**KIRKLEES METROPOLITAN COUNCIL
INVESTMENT & REGENERATION SERVICE**

DELEGATED DECISION TO DETERMINE PLANNING APPLICATIONS

Reference No:	2025/62/92758/E
Site Address:	Land adjacent, 38, Upper Road, Batley Carr, Dewsbury, WF17 7LT
Description:	Erection of one dwelling
Recommending Officer:	Edward Cheseldine

DECISION - REFUSE

PROPOSED HOUSE
ADJACENT
38 UPPER ROAD
BATLEY CARR

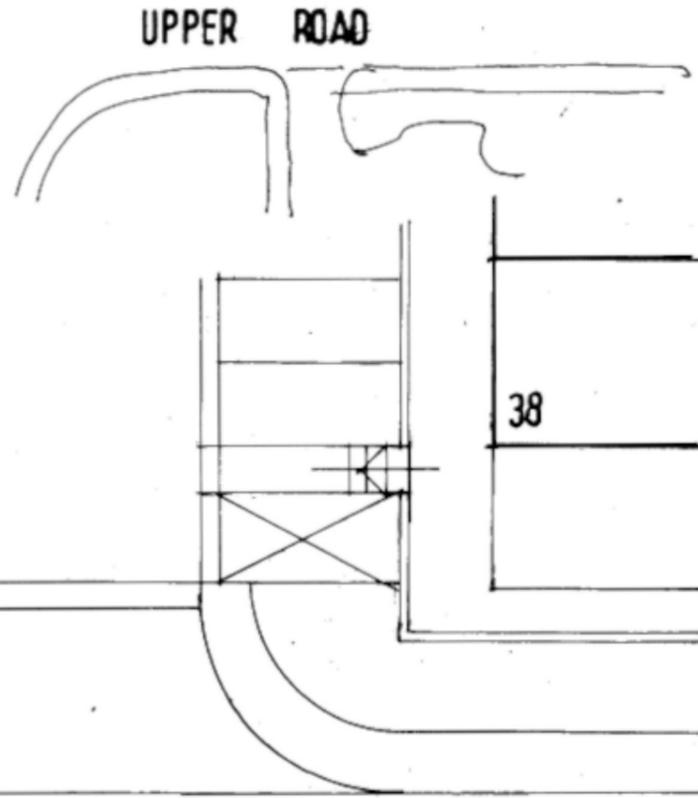
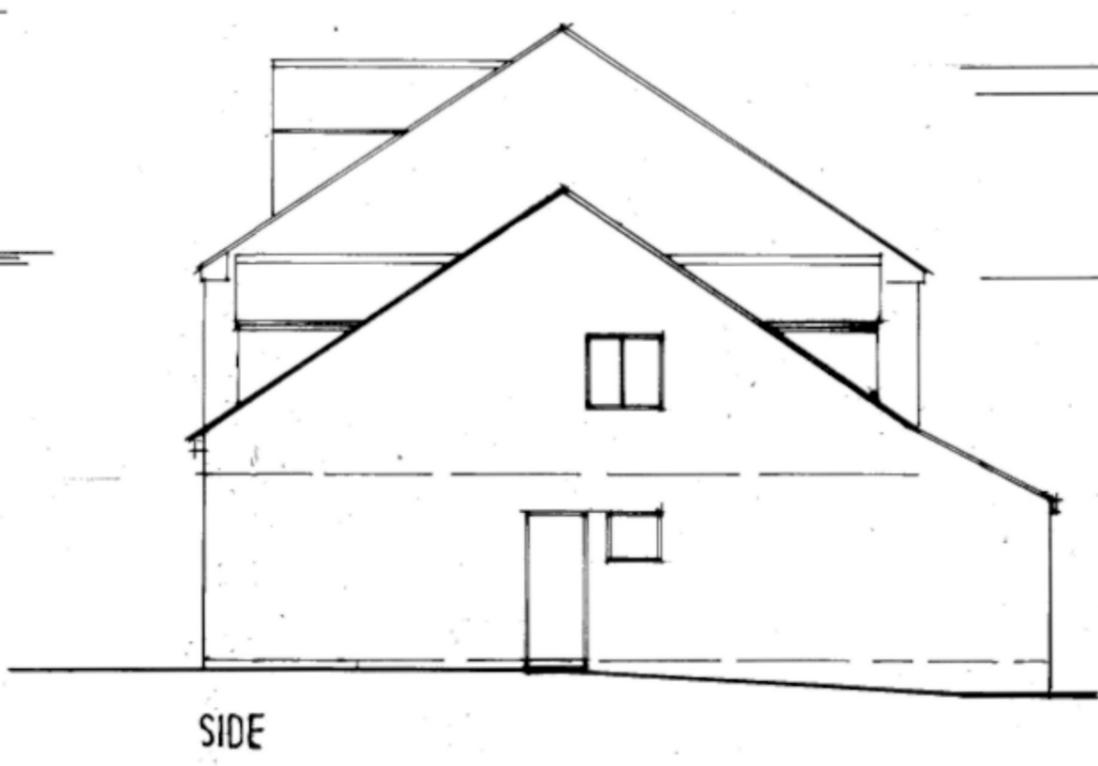
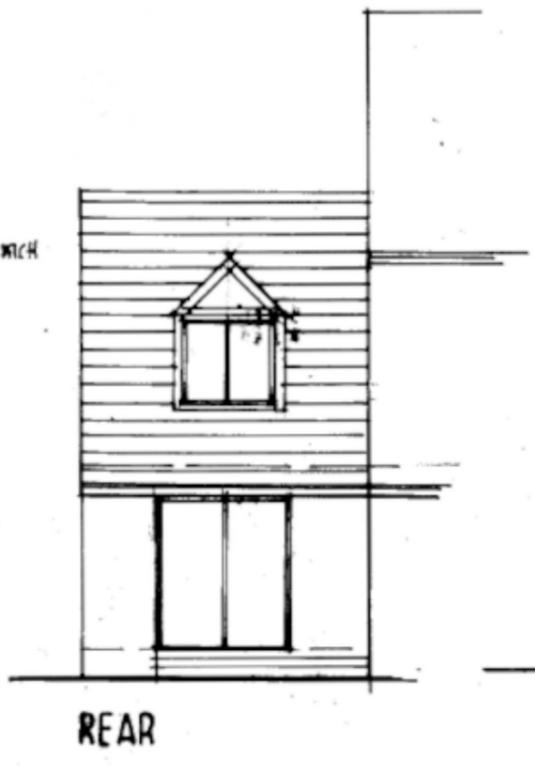
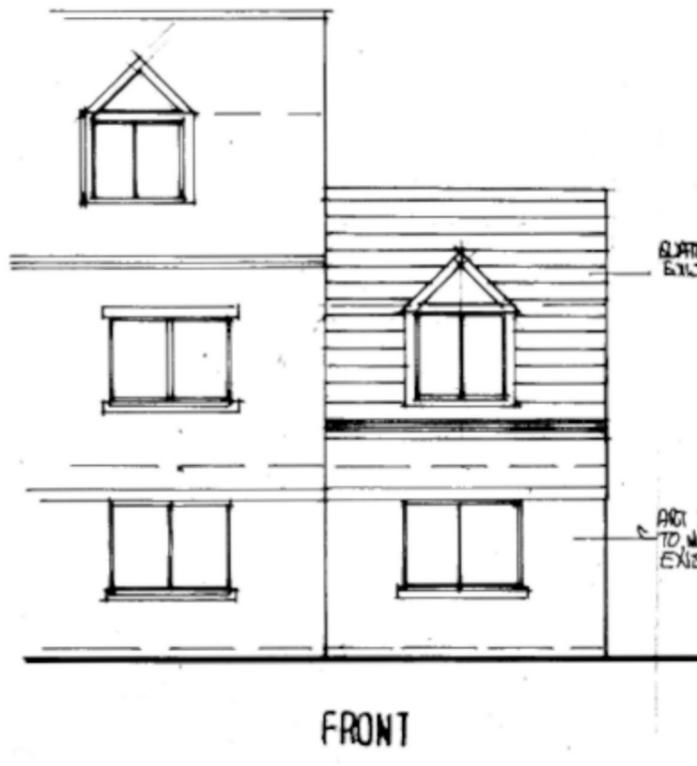
The proposed development would cause a significant adverse visual impact due to its scale, vertical massing, and ridgeline height. The extension would interrupt and obscure key architectural features of the listed building, including its buttresses and a substantial part of the tower. Compared to a single-storey structure, the level of obstruction is excessive given the important contribution of Holy Trinity Church. From Upper Road, the extension would block views up to the mid-section of the church tower, buttresses only barely visible, as

The proposed dwelling would be located in an area of open space adjacent to Upper Road. This land is currently enclosed by a boundary fence, for which no planning permission exists. Existing buildings in the locality are generally set back from the public footpaths, creating generous boundaries and contributing to the area’s open character. Under the proposal, the setback between the terrace row and the public footpath would be reduced from 7.10m to 3.10m. While it is acknowledged that an extant permission exists for

a single-storey dwelling on the footprint of the current proposal, the revised scheme assessed under this application introduces greater vertical mass. In combination with the adjacent terrace row, this increased bulk would erode the openness of the site and harm the established character of the area. Other developments nearby have retained generous front and side open spaces, which this proposal would remove.

The building is set down from the adjoining dwelling, it is single storey attached to a row of two-storey dwellings. There are no other buildings in the immediate vicinity with a similar appearance. Due to its location on a prominent corner plot, it will be highly noticeable from the roadside. The change in scale fails to follow the overall established building form and character of the area. The proposed dwelling will appear relatively narrow. Given the relative scale of the property, with its position, set against the two-storey dwelling, the proposed building will appear contrived within its plot giving a cramped appearance which is contrary to the existing building group.

The building is located in a prominent position on the end of an existing terrace row. The design fails to incorporate an active frontage on the side elevation of the residential dwelling. Given its prominence, the appearance of the side elevation does not maintain or enhance the character of the area which is unsatisfactory in terms of design. Whilst the dwelling mimics the features of the adjoining terrace block, its low form will add to the incongruity of the dwelling as it sits on the end of established buildings that are built in uniformity.

In terms of roofline, a pitched roof has been chosen in an orientation of the other buildings to the north. As previously discussed, whilst the orientation matched the terrace row, the height of the structure will present a stepped down approach which does not accord within the adjoining building group.

2. The proposed development, due to scale and positioning would have a detrimental impact within the streetscene, reducing the sense of openness within this section of Upper Road, whilst appearing incongruent within the building group due to its appearance. It would be contrary to Principle 2, 5, 14 & 15 of the Housebuilders Design Guide Supplementary Planning Document, Policy LP24(a) of the Kirklees Local Plan and Chapter 12 of the National Planning Policy Framework.
